**From:** Patel, Uday <Uday.Patel@lancashire.gov.uk>  
**Sent:** 16 October 2014 11:20  
**To:** planning  
**Cc:** ENV LHS Customer Service  
**Subject:** 3/2014/0834 - Proposed new dwelling off Back Lane to the rear of stonecroft Rimington - Stonecroft Rimington Lane Rimington BB7 4DS

**Planning Application Reference: 3/2014/0834**

**Proposal: Proposed new dwelling off Back Lane to the rear of stonecroft Rimington**

**Location: Stonecroft Rimington Lane Rimington BB7 4DS**

GROUND FLOOR PLAN

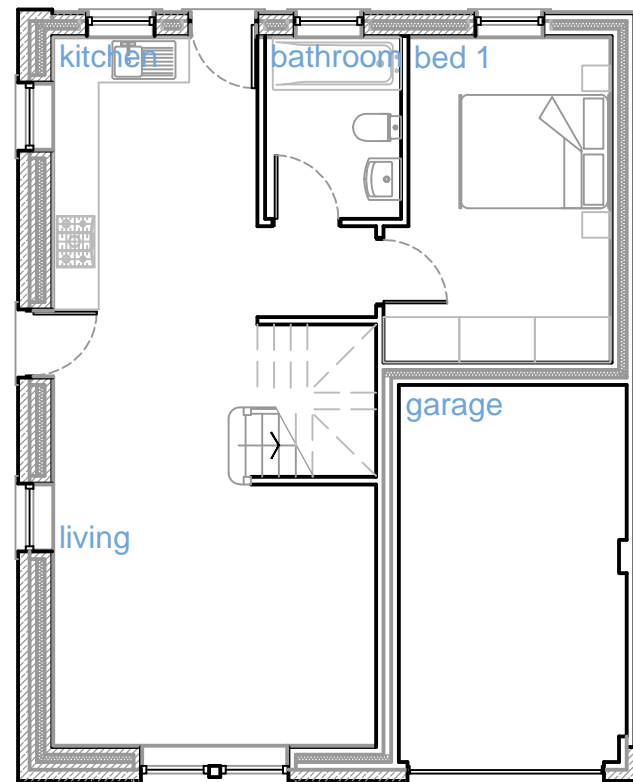
Proposed development is erection of a single dwelling off Back Lane. Back Lane is a 2 way road with 30mph speed limit. It is a narrow road and believed to be used mainly by the residents around the road. Proposed development consists of ground floor and first floor including garage and forecourt area. Ground floor consists of living area kitchen and one bedroom. First floor of the development consists of one bedroom and study room including utility area. Thus there are two bedrooms in the dwelling. It is believed that study room can easily be converted in to third bedroom in the dwelling.

Drawing Name: PROPOSED SITE PLAN

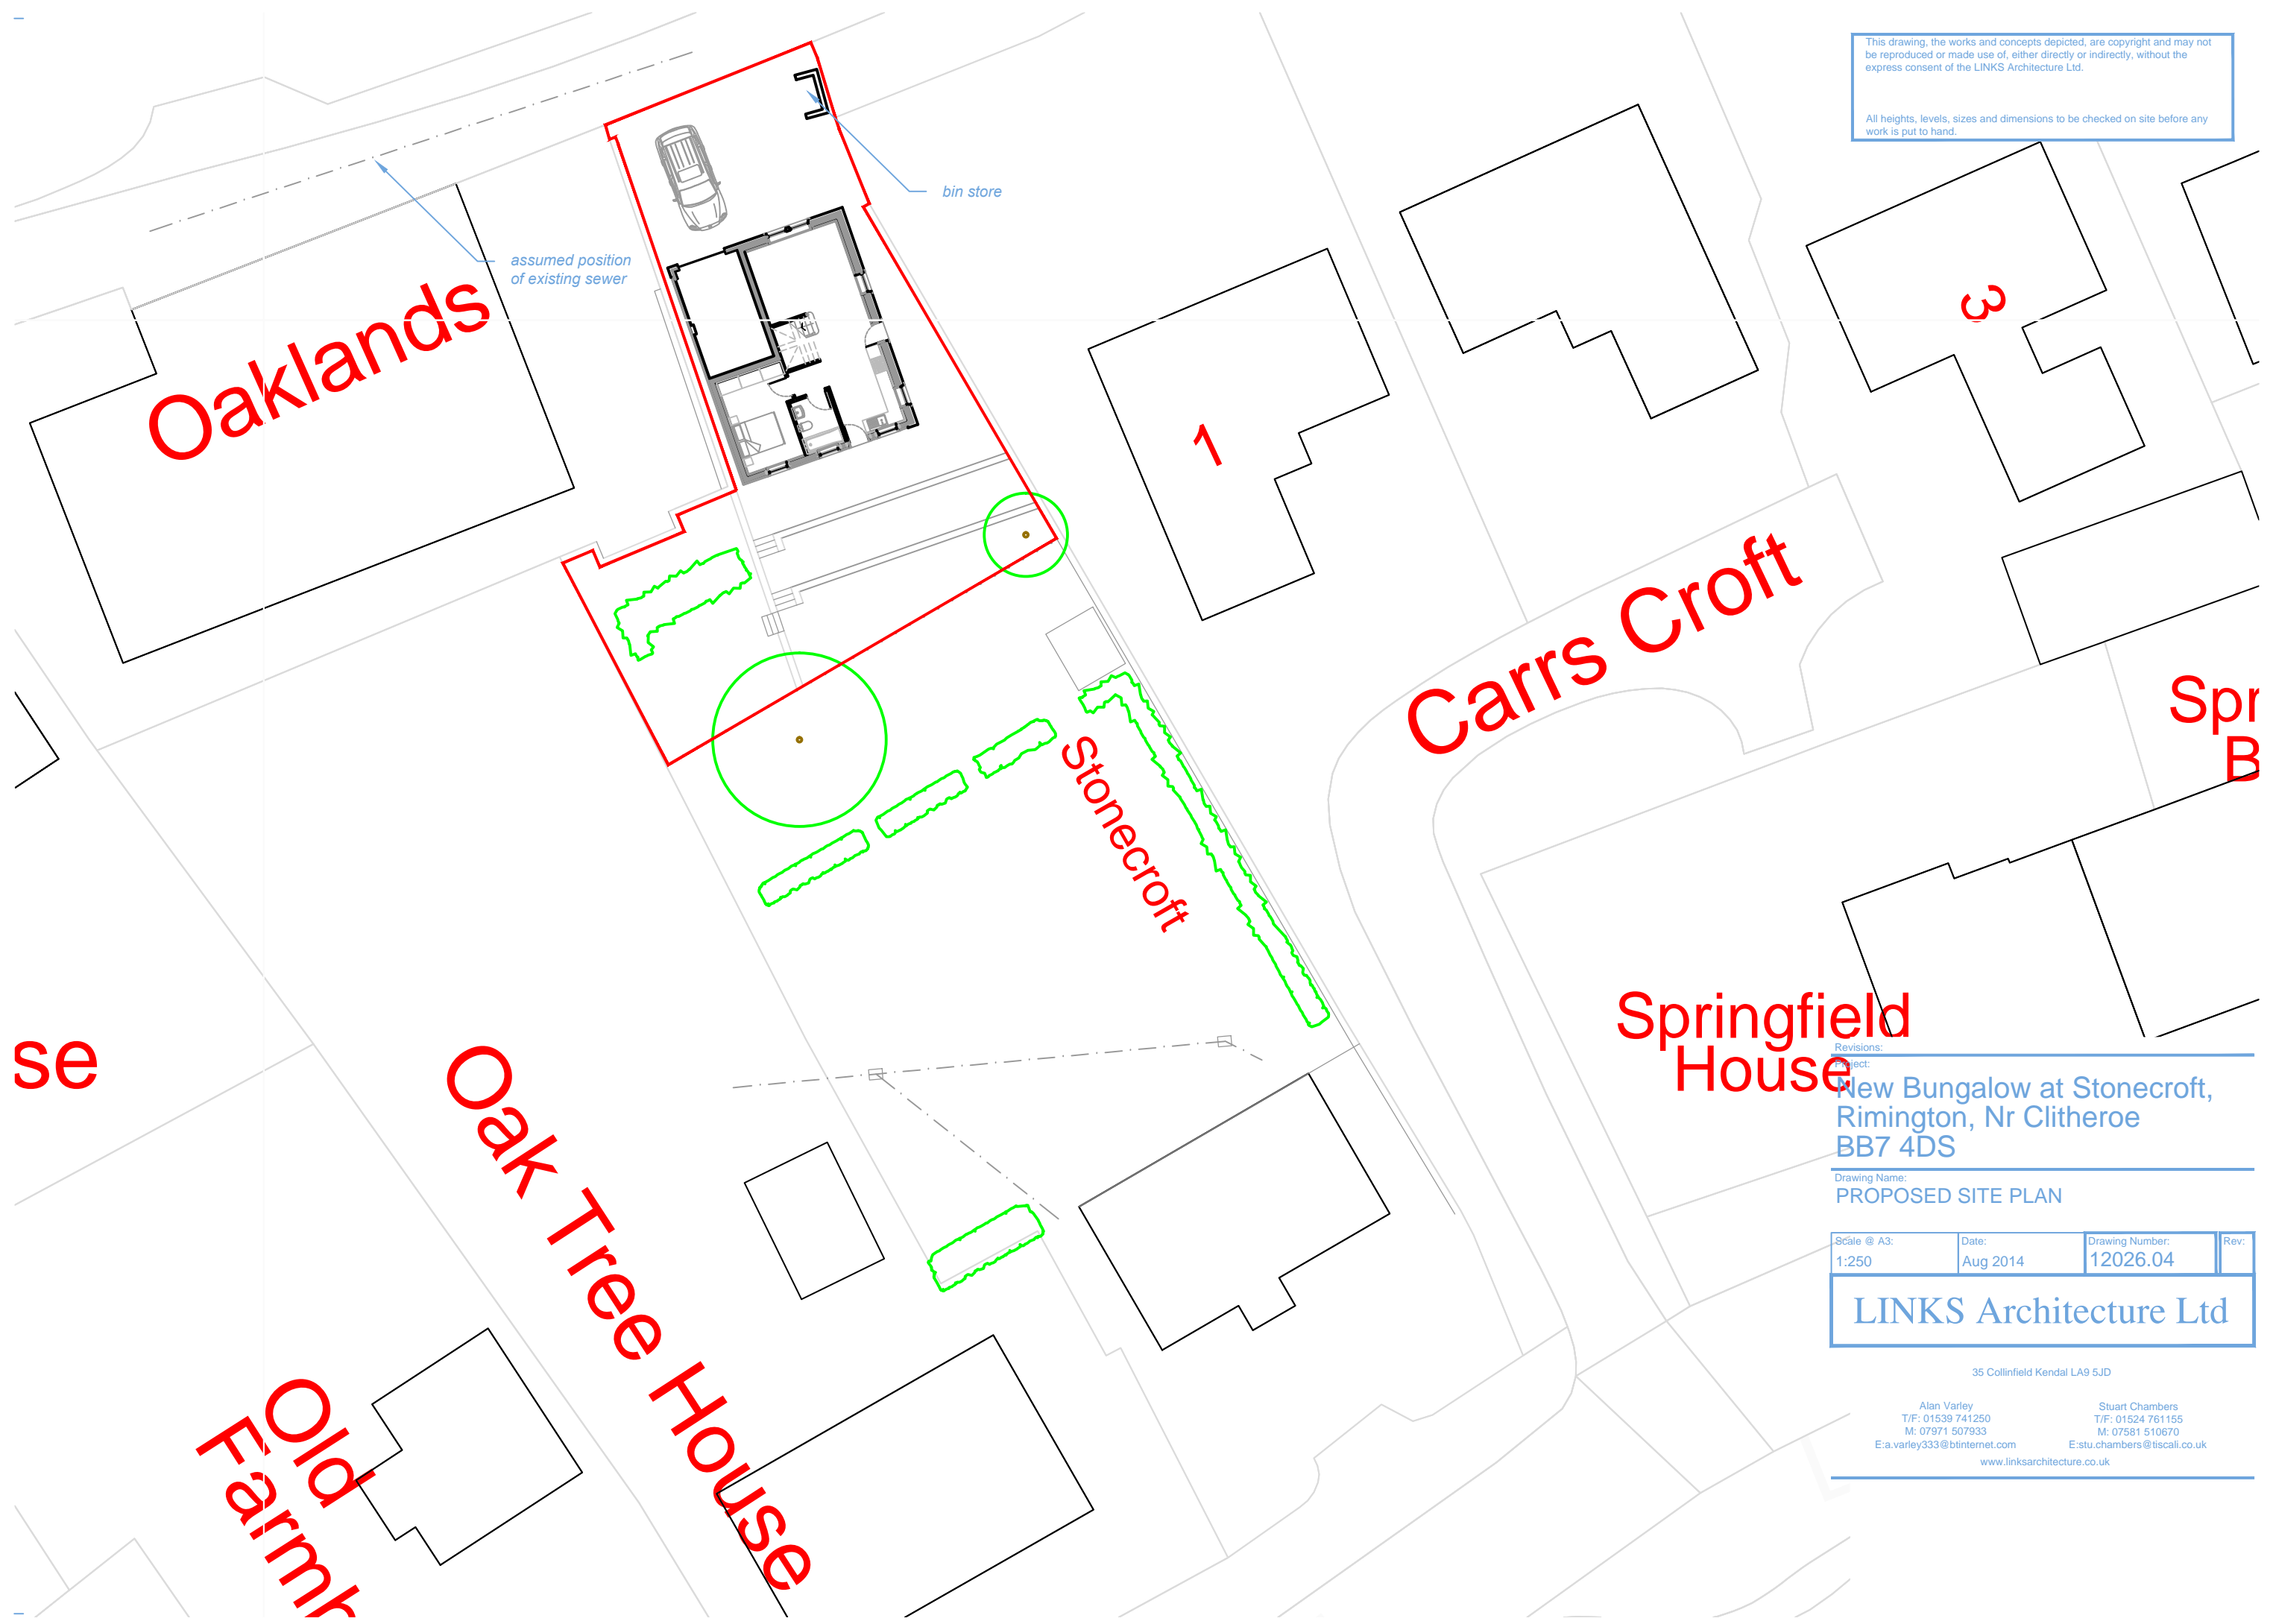
1. Applicant need to demonstrate the details of parking including dimensions to satisfy the Highway Authority of provision of parking of two vehicles off the road in a safe manner.

2. According to JLSP residential standard guidelines, 2-3 bedroom dwelling shall require 2no parking spaces within curtilage of the property. Layout plan indicates garage and forecourt area within curtilage of the property. It is to mention that according to manual or streets, standard dimension of garage is 3mx6m to consider one vehicle parking and standard dimension of parking bay in the forecourt is 2.4mx4.8m.

3. Applicant to demonstrate vehicle turning area within curtilage of the property to exit the vehicle in forward gear position.
4. Any structure (wall/fence), hedge, vegetation to the highway frontage (Back Lane) shall be reduced to 1m from the crown of the adjacent road (Back Lane) and shall be maintained accordingly to facilitate the visibility on the road.

Based on the above observations, it is necessary to amend the layout accordingly.
